RFS

State Significant Development - Residential Subdivision/Masterplan

Request for comments - exhibited Environmental Impact Statement (EIS)

Site R3 - Macarthur Gardens North, Affordable Housing GOLDSMITH AVENUE CAMPBELLTOWN NSW 2560, 1097//DP1182558

Figure 2: Bushfire Hazard Assessment

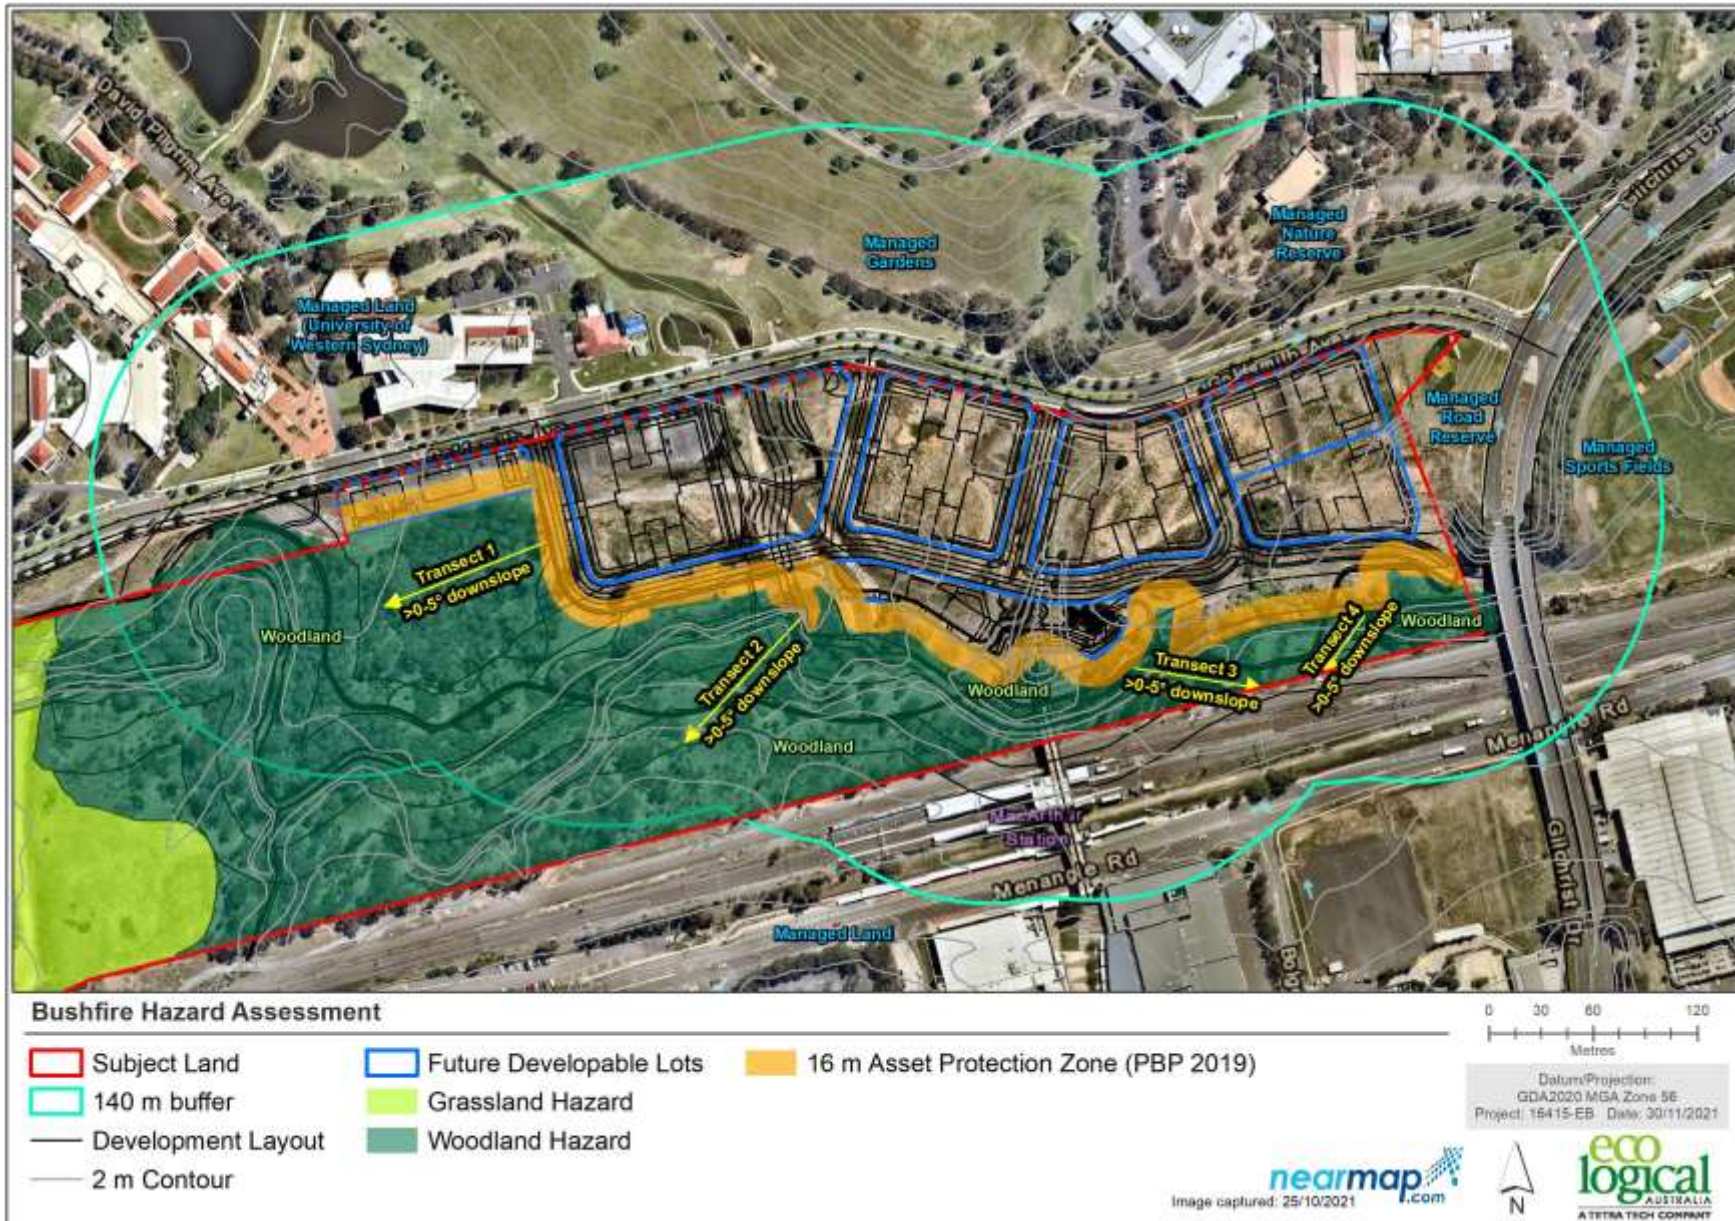
In terms of Bushfire Attack Level (BAL) construction requirements, it is unclear what separation distance will be present between the proposed residential apartments and unmanaged vegetation to the south/southwest. Consistent with the requirements of Planning for Bush Fire Protection 2019, BAL construction measures relative to the available separation distance shall be provided.
